From: PETER SHAW <[REDACTED]>
Sent: 17 January 2020, 14:44
To: Amber Willard
Subject: Re: aw/297/19/hh

I am the officer on your application at Strawberry Cottage, Cypress Way.

Drawing:
Proposed car barn and storage

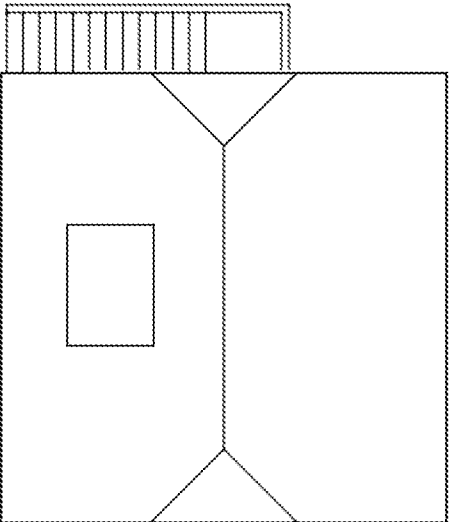
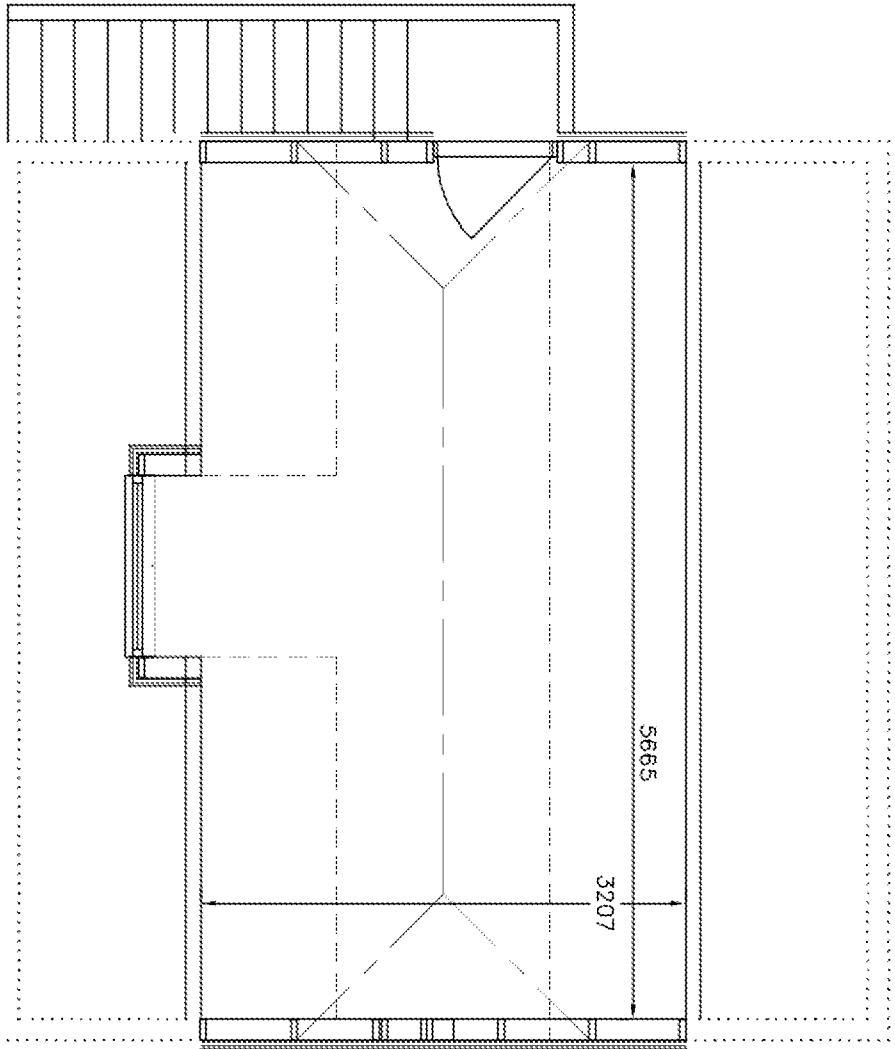
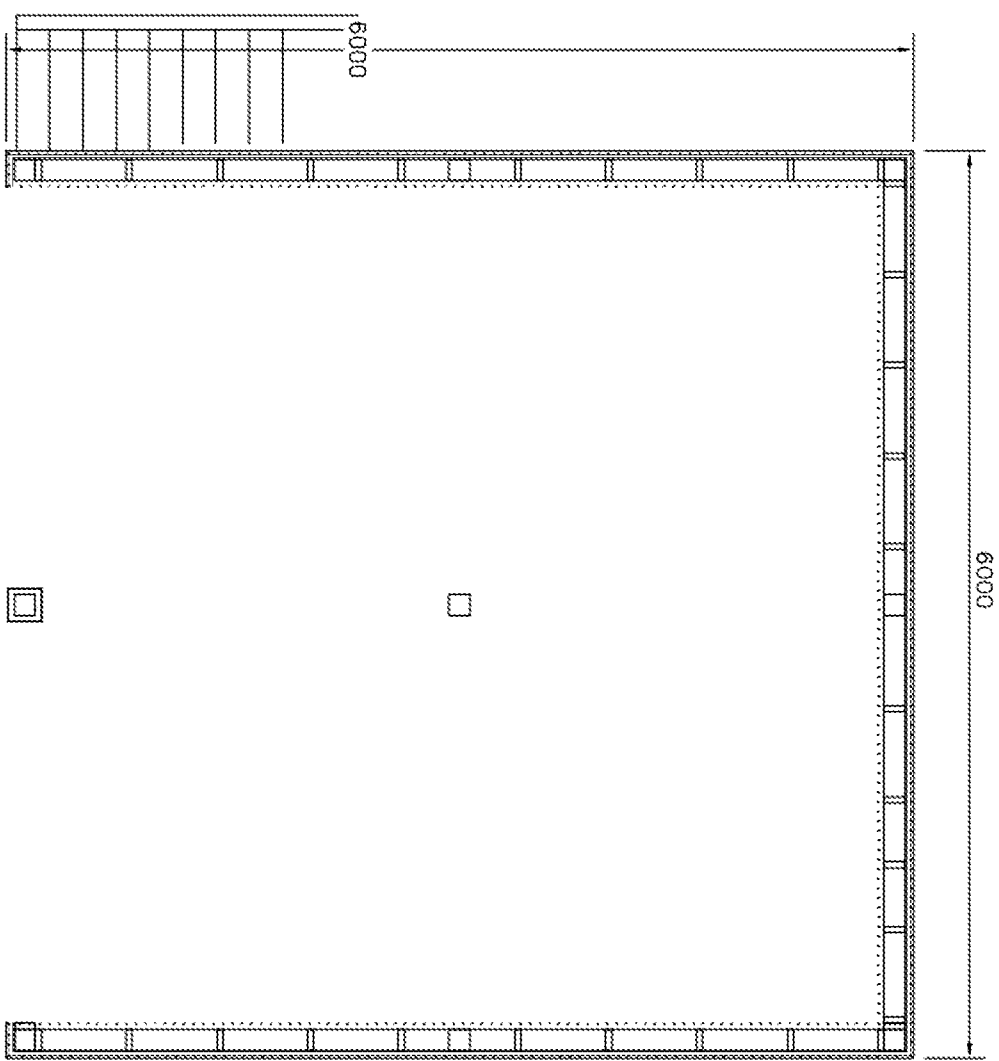
Unfortunately he has objected to the scheme as the proposed car port would adversely impact the trees on site, some of which are protected.

He has requested an Arboricultural Impact Assessment (AIA) be submitted which must be inclusive of; a 'Tree Survey Schedule', a 'Root Protection Area (RPA) Schedule' and a 'Tree Constraints Plan' – with the trees accurately plotted on same.

'In the event that a RPA of any tree which is proposed for retention overlaps the development then BS5837:2012 requires that the Detailed Planning Application is accompanied by an Arboricultural Method Statement (AMS) and also most importantly a Tree Protection Plan – to both describe and illustrate the mitigation measures which are to be employed to ensure that the trees survive without detriment to their vigour and vitality and are given adequate protection both above and below ground'.

Following discussion with the applicant it has been decided to withdraw the car barn from the application, its provision and position will be reviewed later.
